Bruce Hunter
905/50 Murray Street
Pyrmont, NSW 2009
17 January 2017

**Objection to the proposed redevelopment (SSD 7874) of Harbourside Shopping
Centre with Residential Tower**

Bruce Hunter - SSD 7874 Objection - Page 2

11am

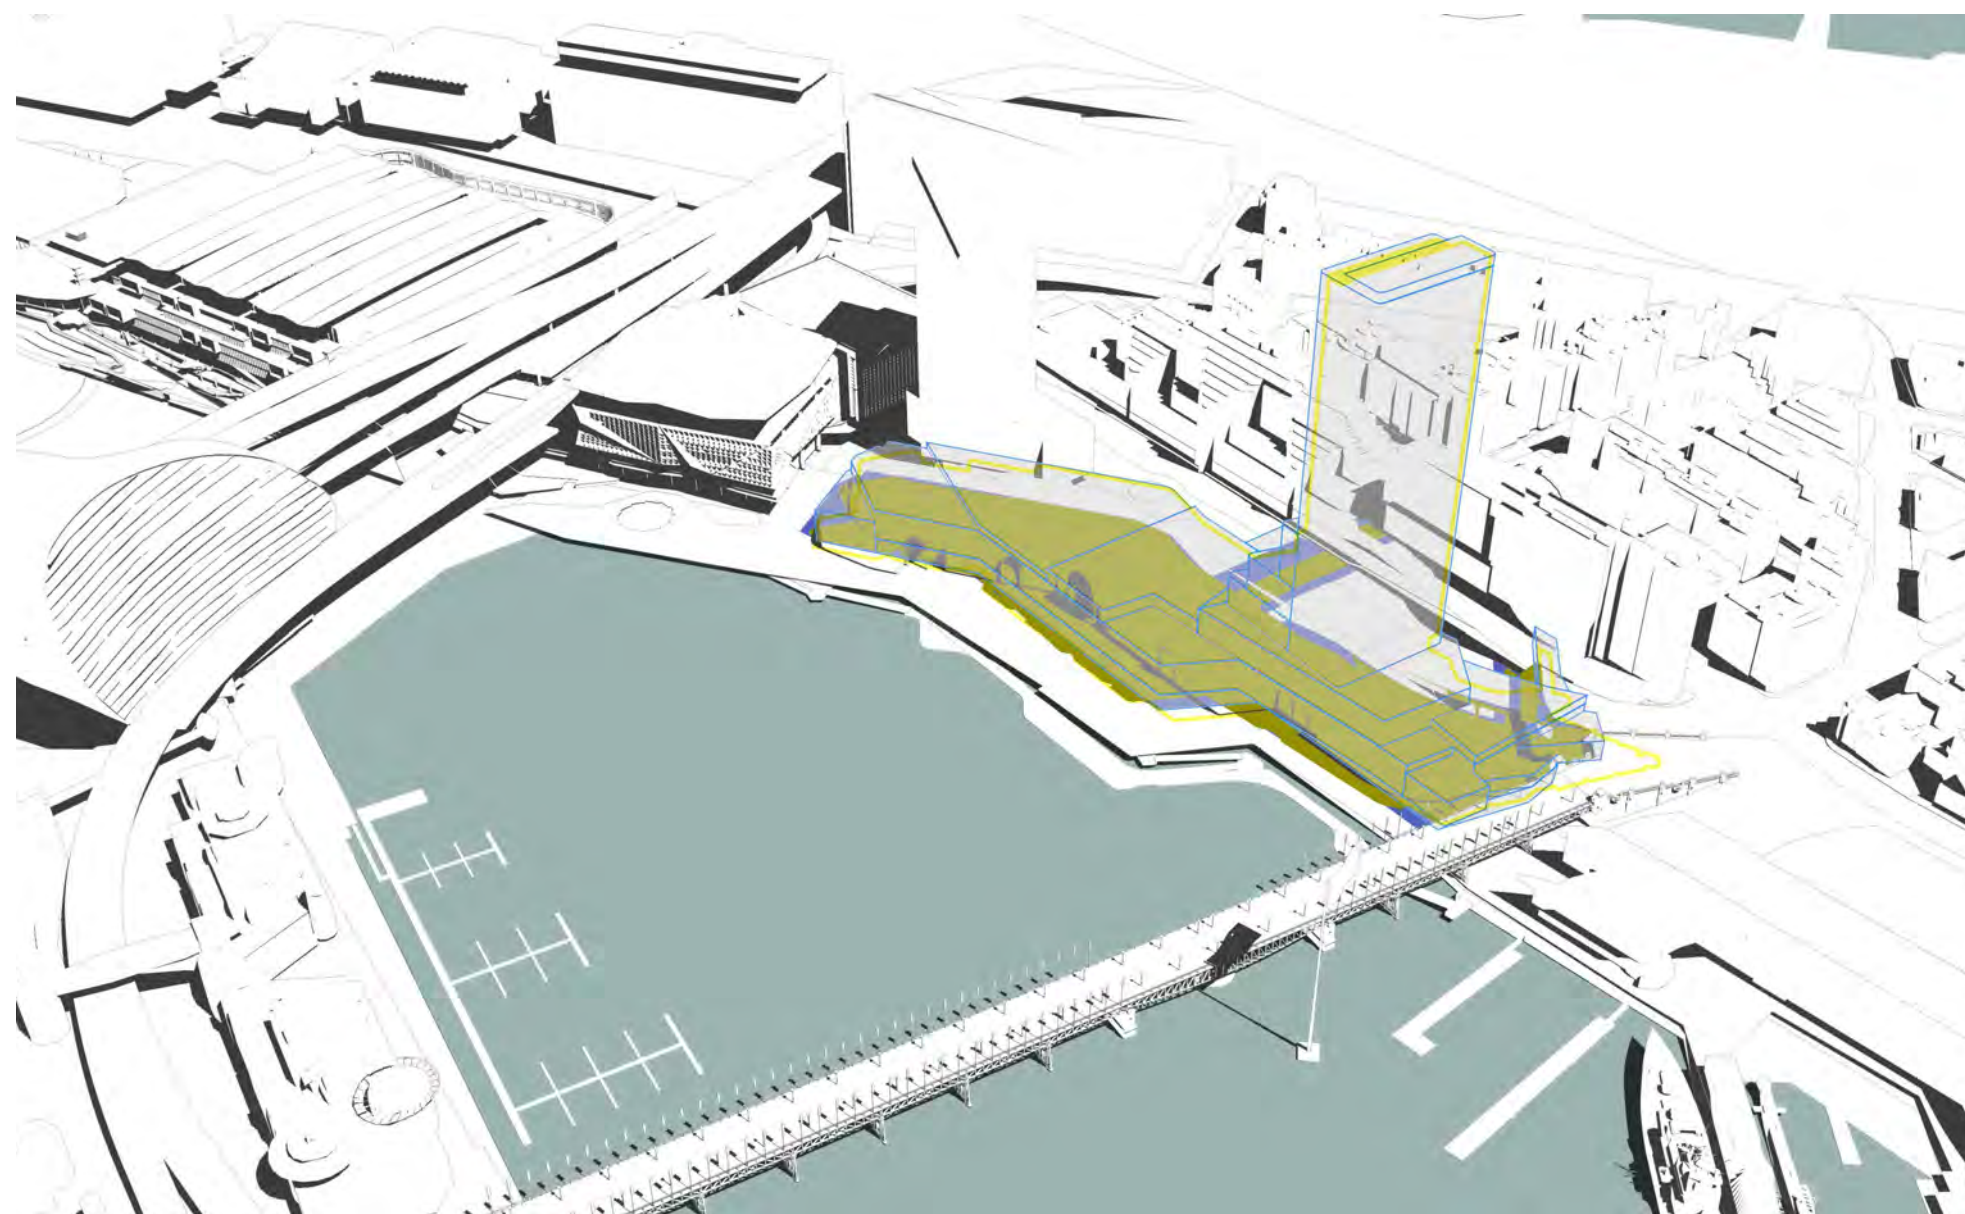
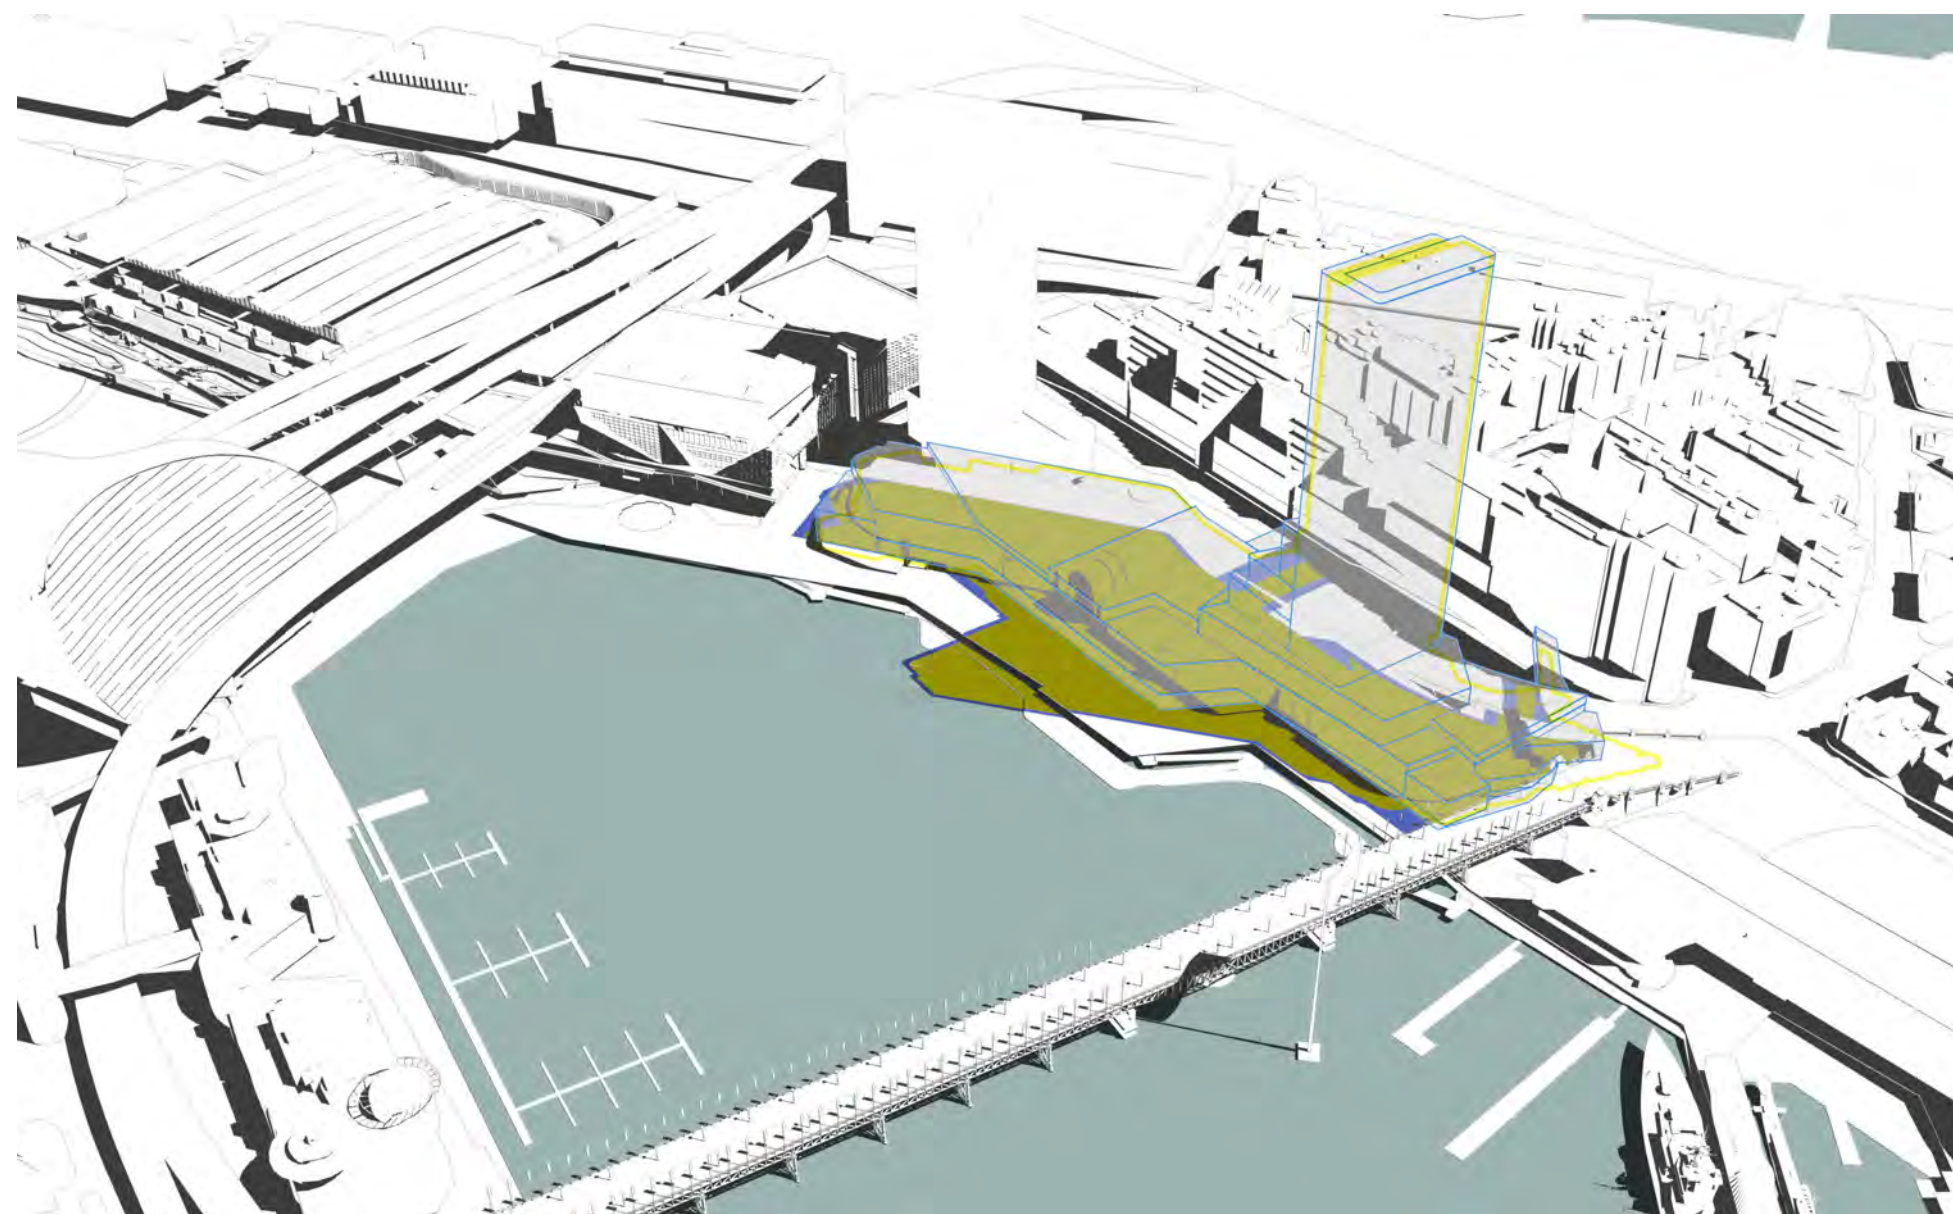
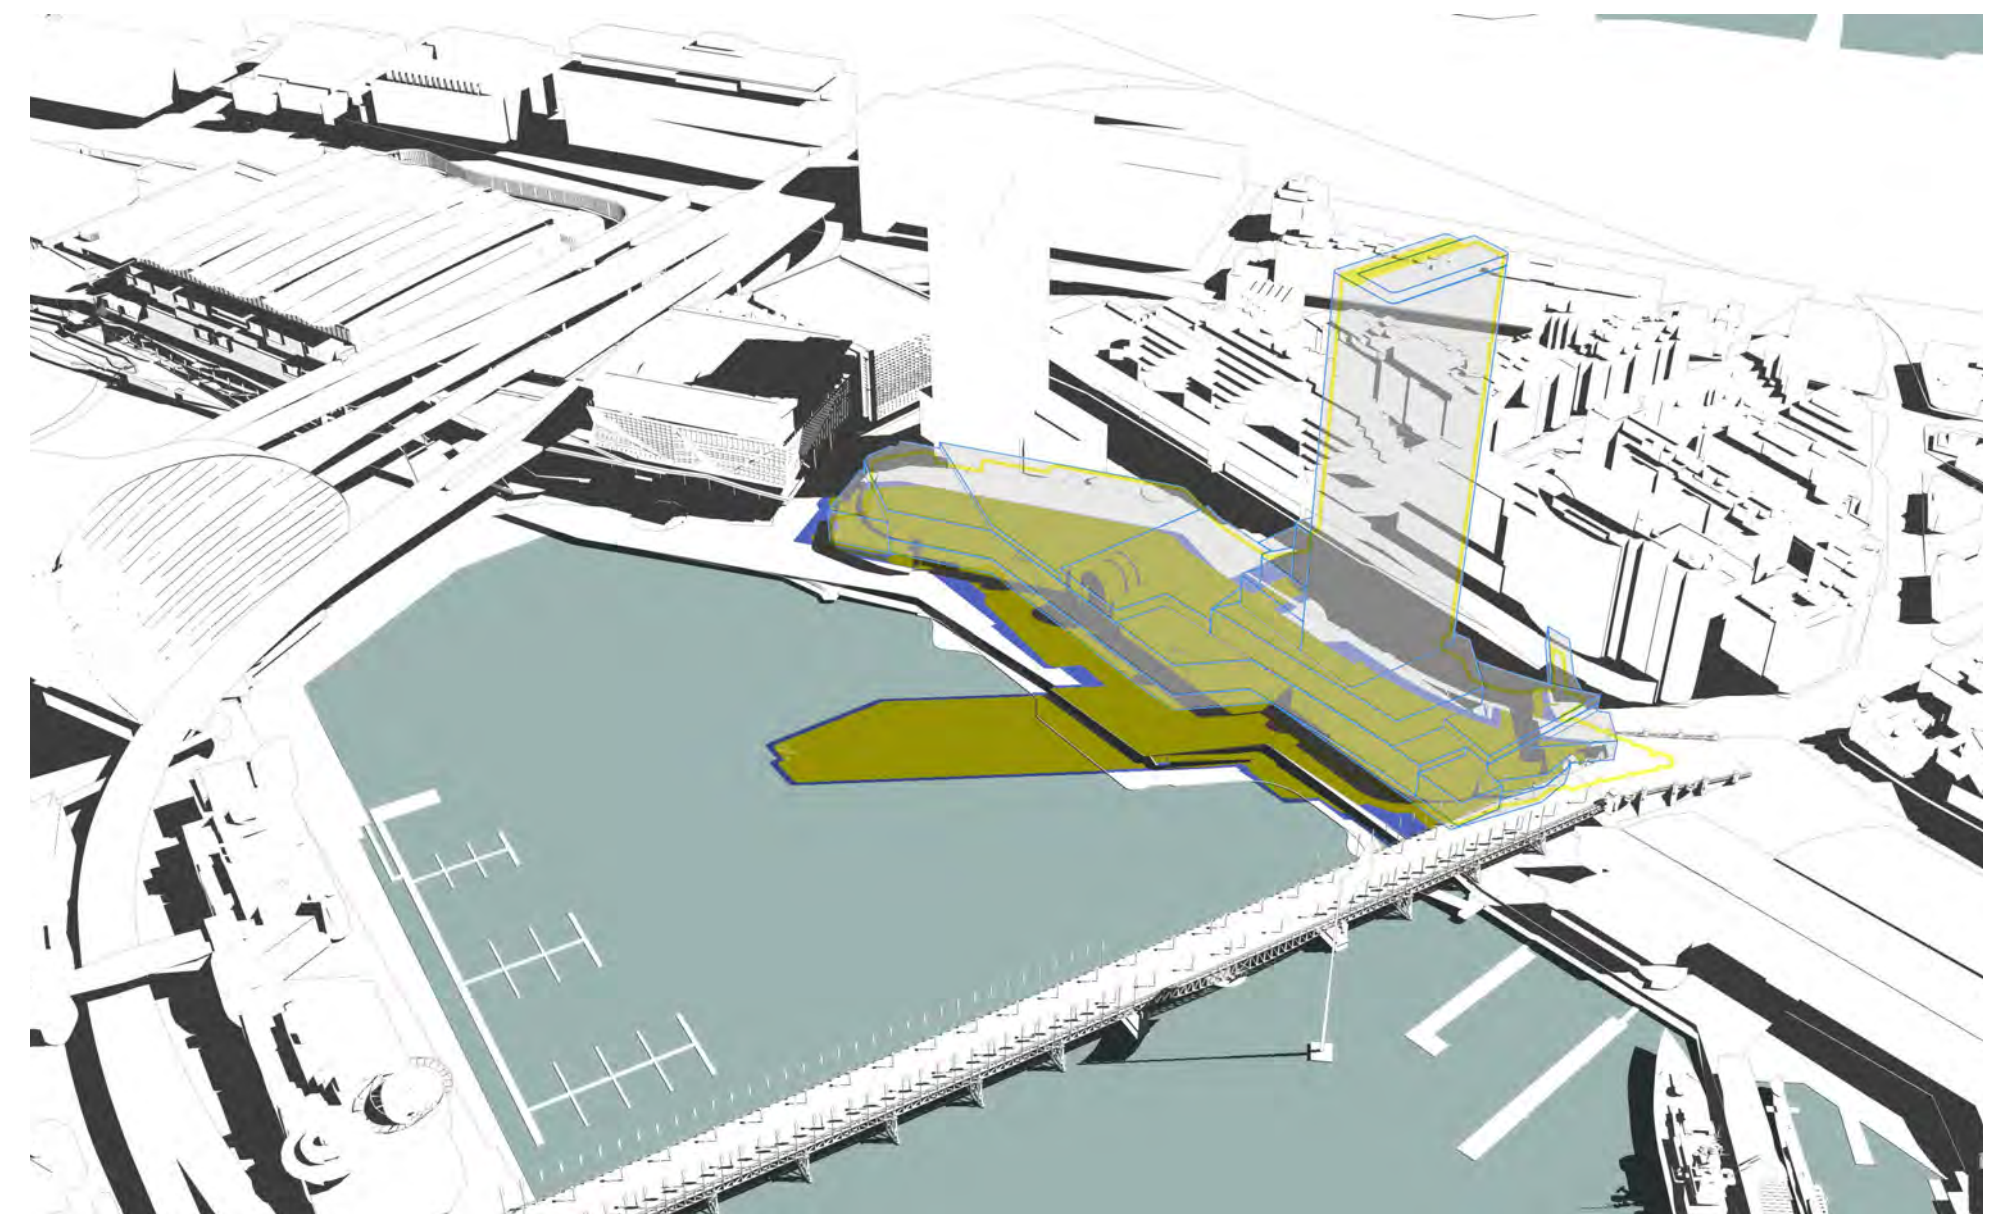
2. There is no justification for the tower included, with the shadow diagrams showing significant shadow impact on Darling Harbour and the residential areas on the western side towards Pyrmont.
